Land off Bilsham Road, Yapton.

I am writing to you on behalf of my client Bilsham Road LLP ("the Applicant") in regards to ithe Reserved Matters Application for the above development on Land off Bilsham Road, Yapton ("the Site").

Following a request for further information, I am pleased to provide our response as set out below.

CLIENT:	Bilsham Road Development LLP	PROJECT:	Bilsham Road Yapton
SCALE:	1:100 (A1 ORIGINAL)	DRAWING:	C2H4 & C3H5 - Terrace Full Plans & Elevations
DRAWN:	GE	19284	P220
DATE:	July 2021		A

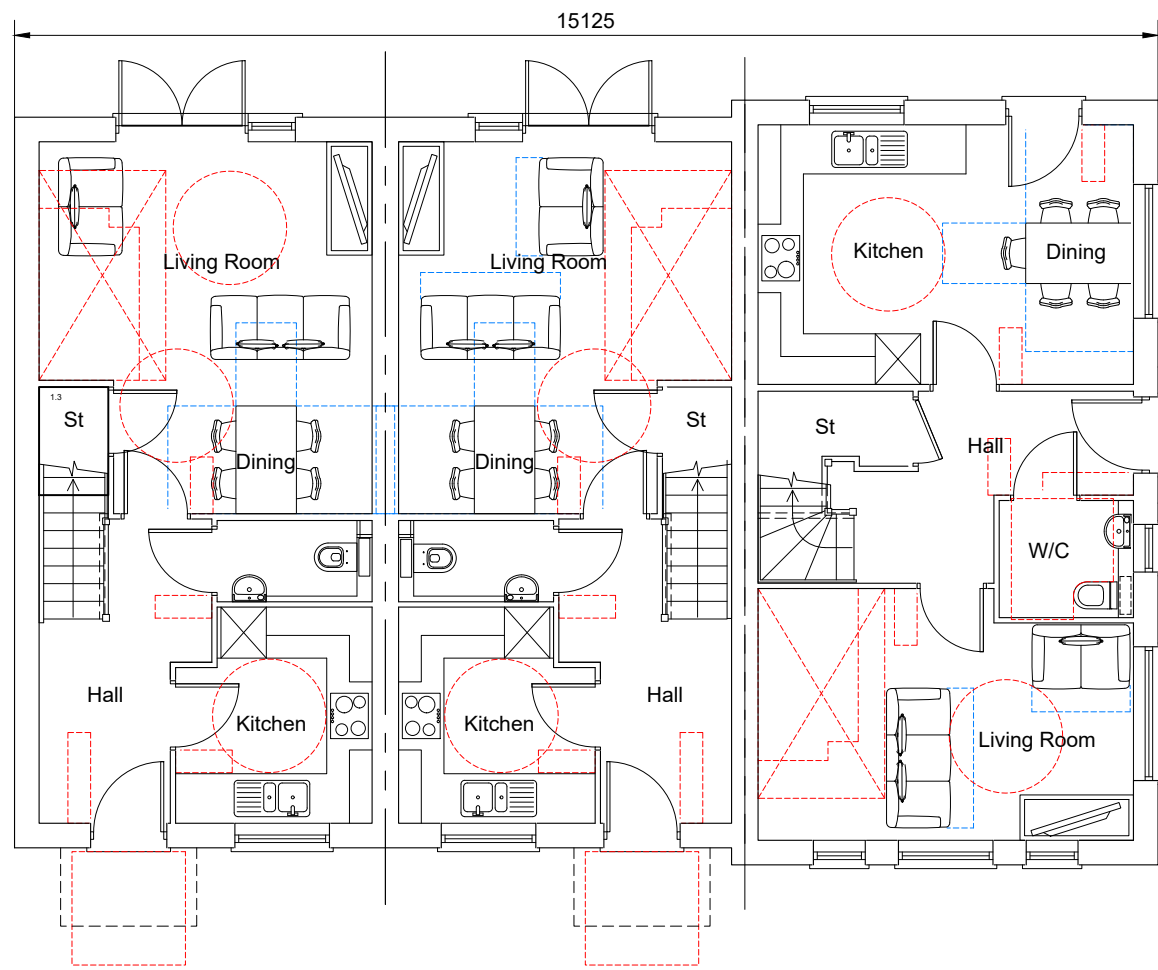
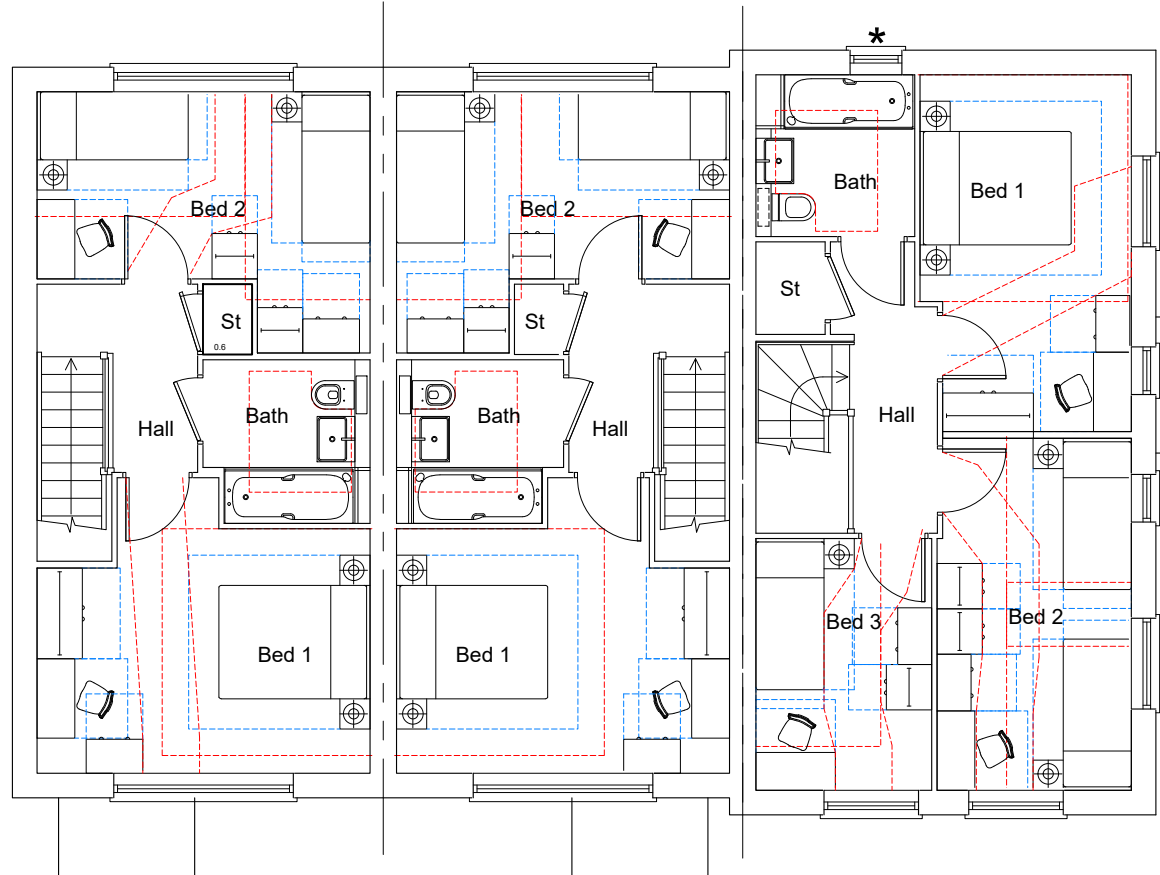
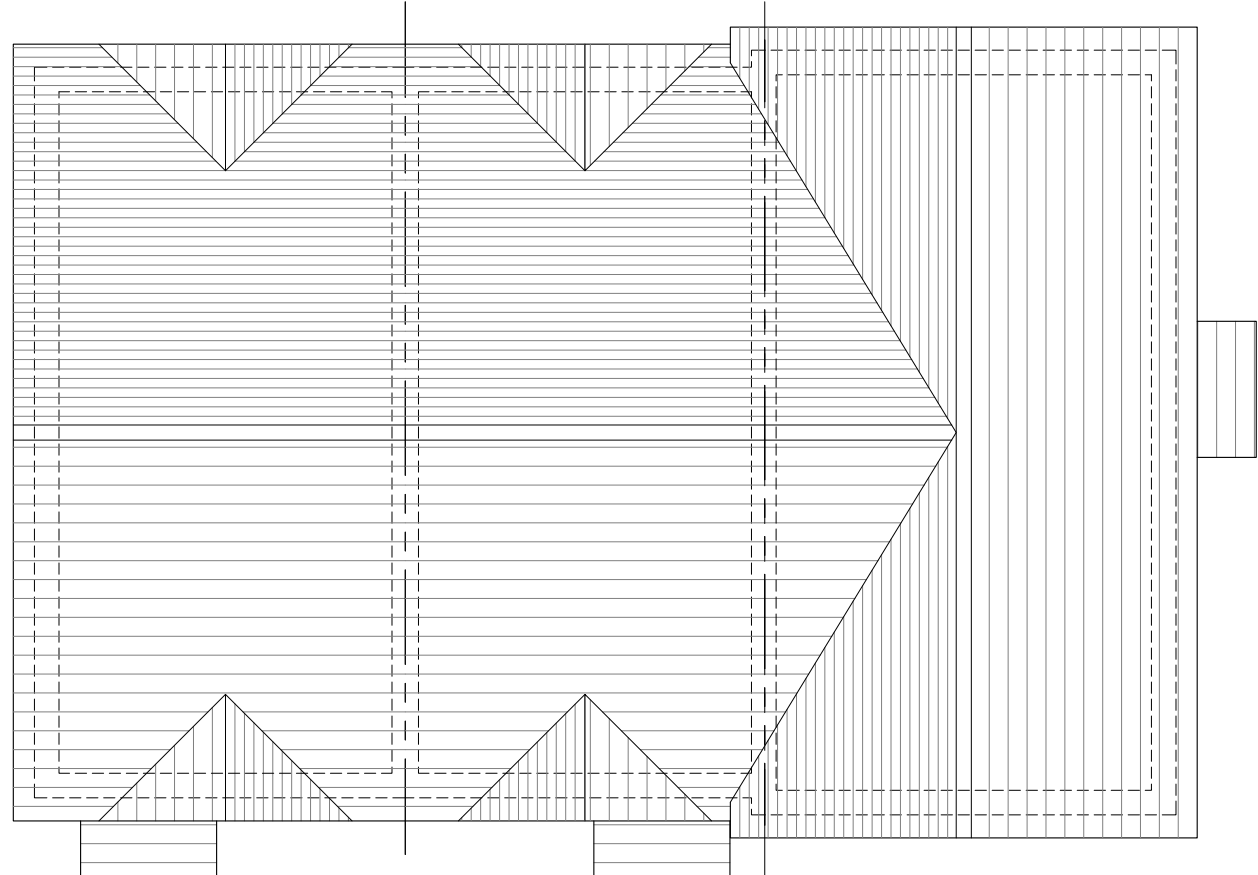
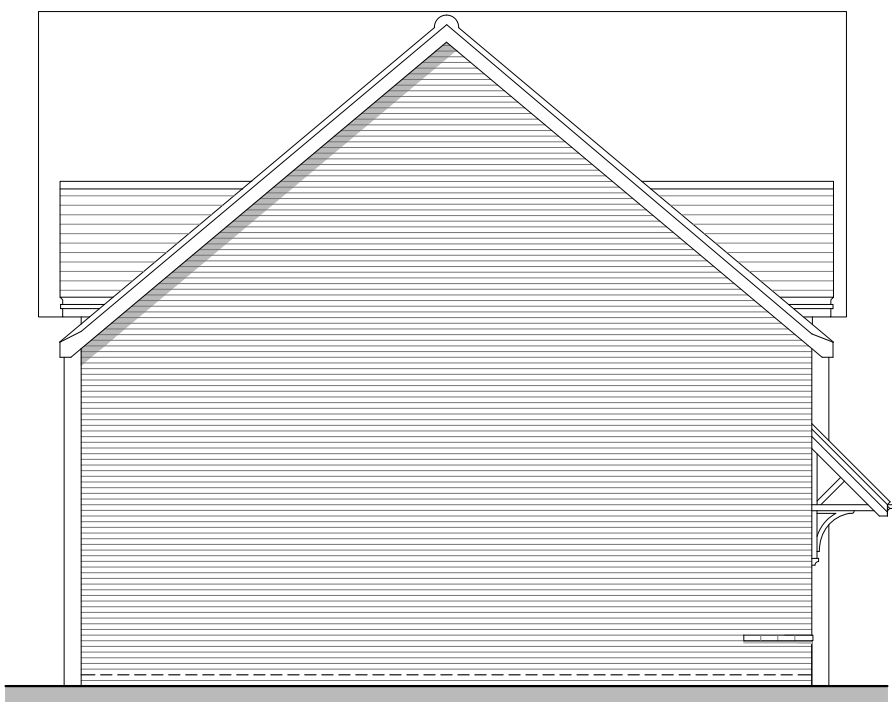
Tree Officer – Concern regarding Tree T8 RPA

In order to address the comments raised by the Tree Officer, the Applicant has amended the alignment of plots 91-93 to ensure there is no rear garden within the RPA. Further comments were received regarding a 2m buffer zone and this has been incorporated into the scheme where possible and resulted in minor amendments to parking for plots 91-92 to ensure there is no encroachment within the 15m RPA and 2m buffer. Whilst several amendments have been proposed to remove development from the RPA, it was not possible to completely remove the proposed footpath running to the north of tree ref:T8 as this is proposed in compliance with the approved Design Code. Therefore the removal of this footpath would have significant implications on the design of the Main Street and it was agreed between the Applicant and Tree Officer that measures set out in the updated Arboricultural Impact Assessment would be suitable to ensure there was no impact on the tree T8.
